From: Amanda Scholes on behalf of Planning.Responses
Sent: 19 June 2018 08:23
To: Planning Scanning
Subject: FW: BE/40/18/PL

From: Laura Gibbons
Sent: 18 June 2018 13:56
To: David Easton
Subject: RE: BE/40/18/PL

Engineers Comments Regarding Surface Water Drainage

Proposed Access to New Barn Lane

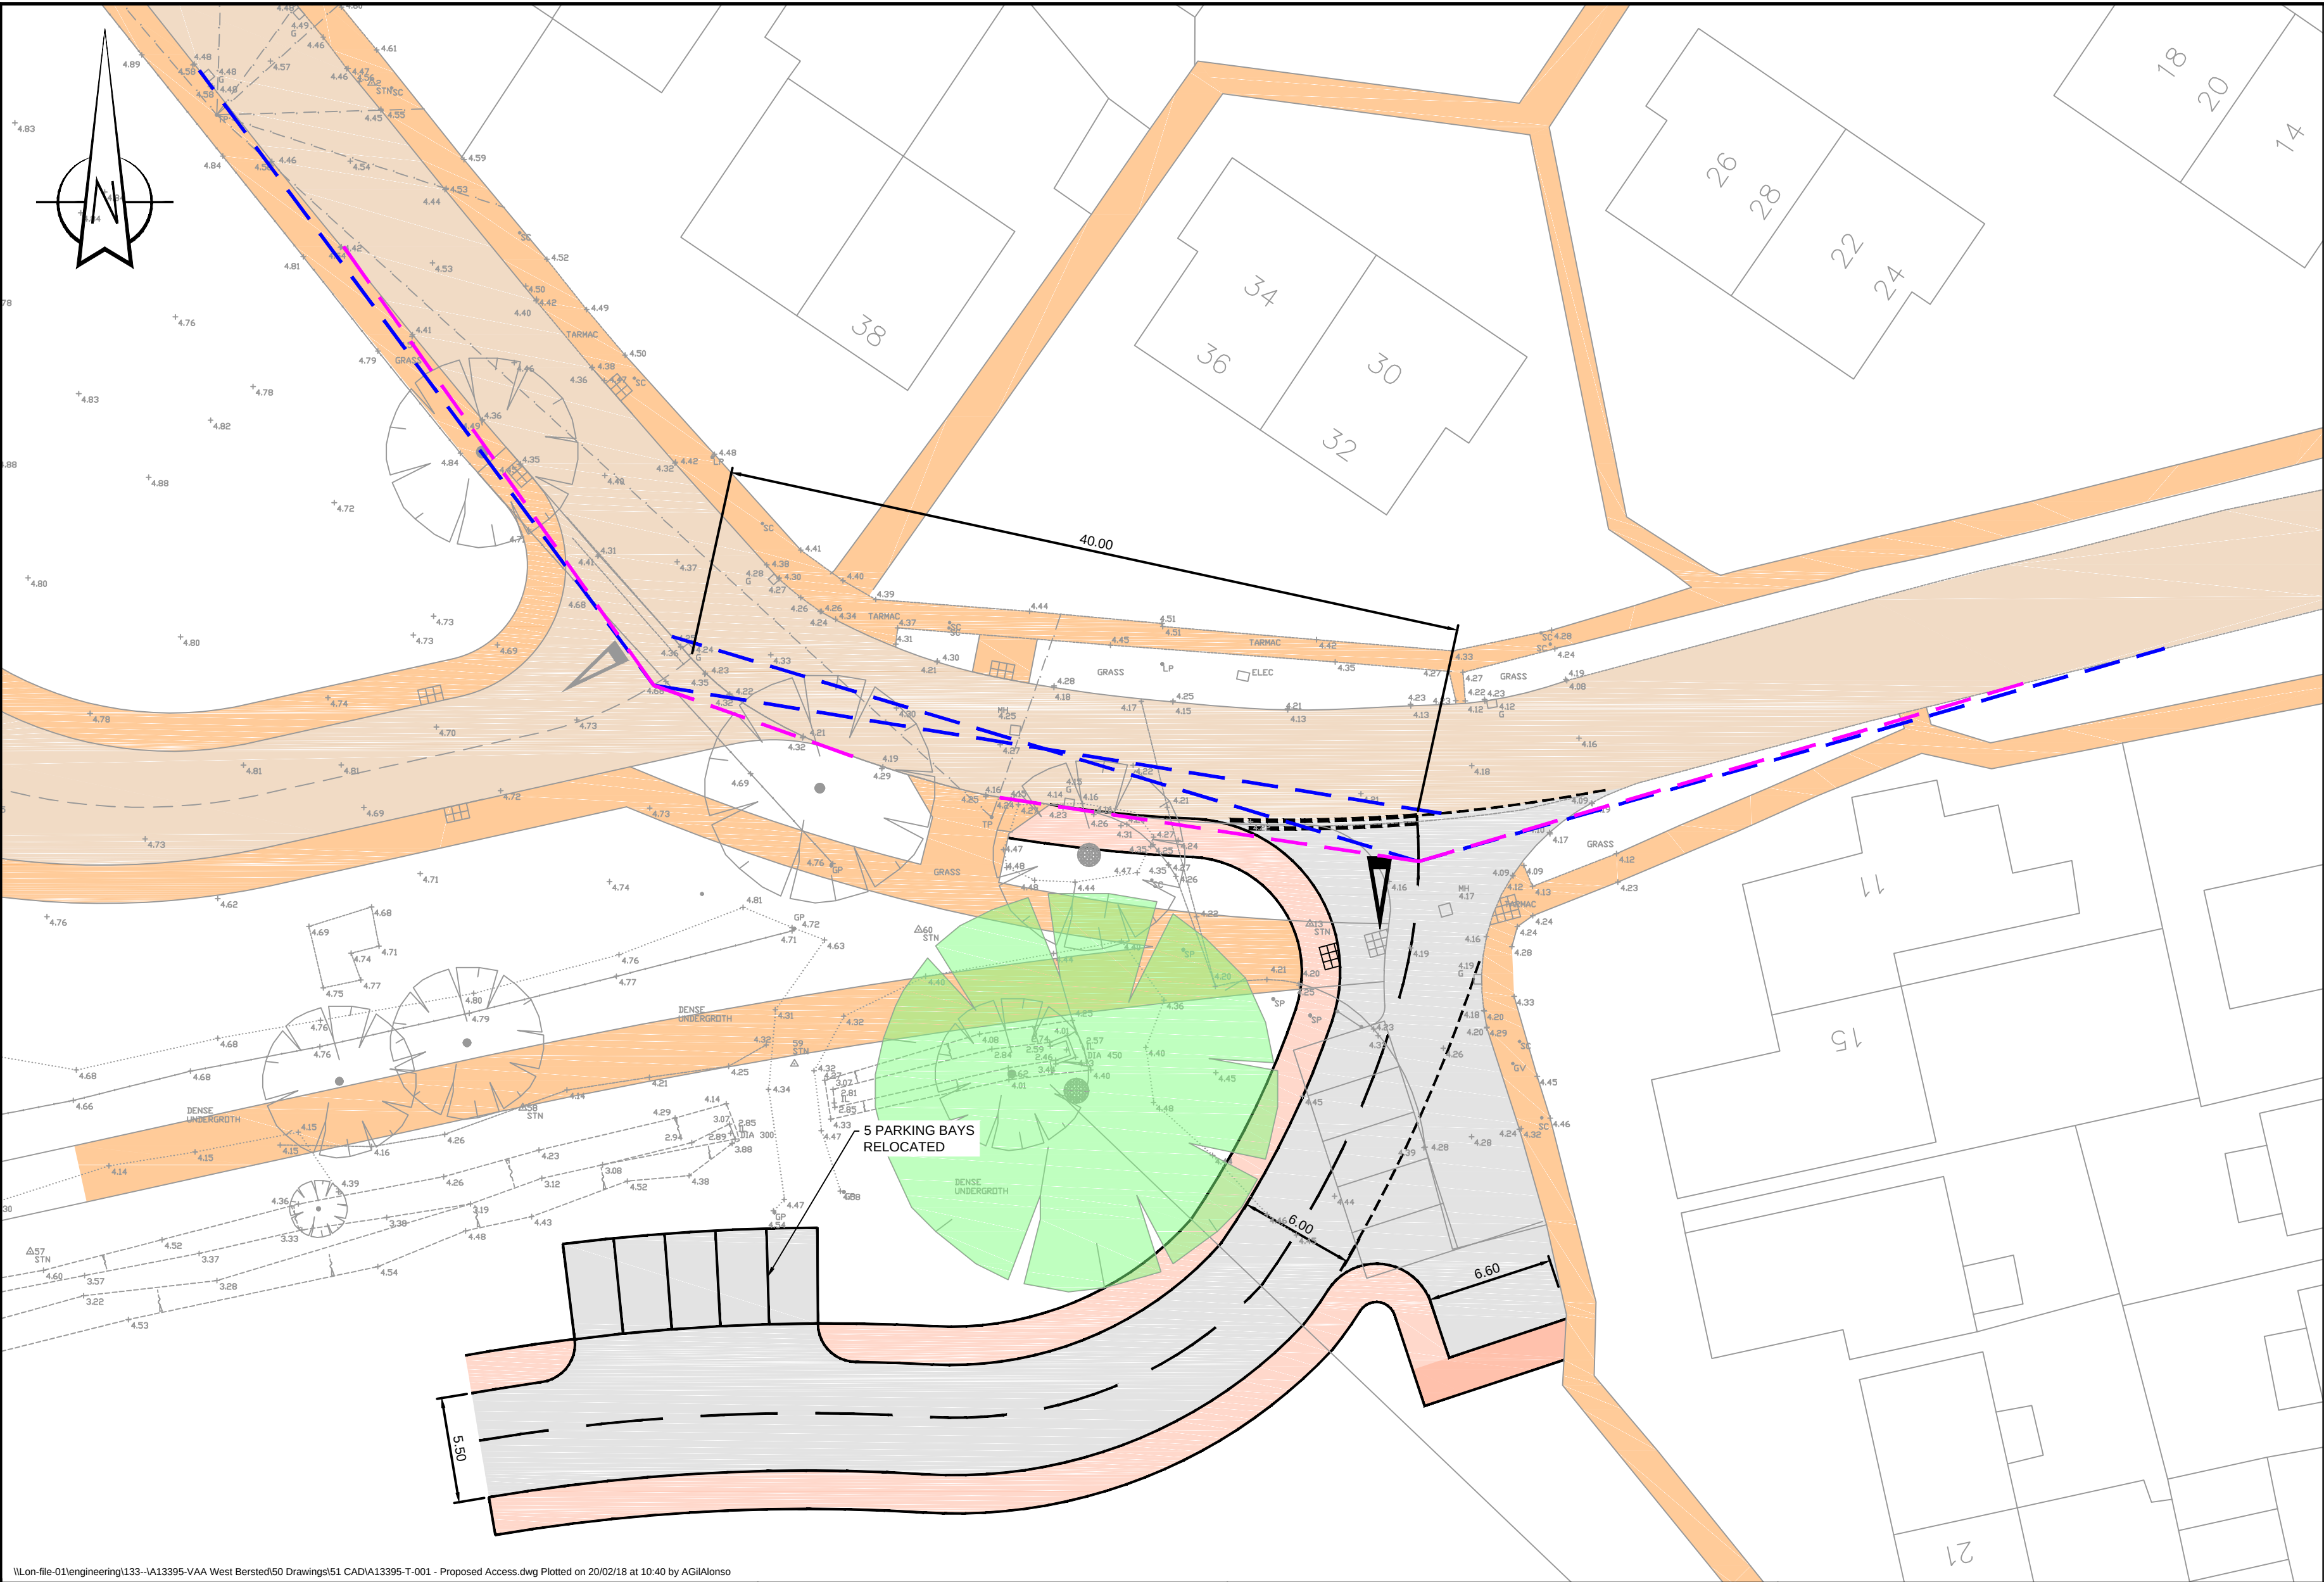
There is currently a culvert to the north of the proposed parking bays, this is a redundant field crossing and will need to be removed as part of the wider ditch improvement works to the proposed site.
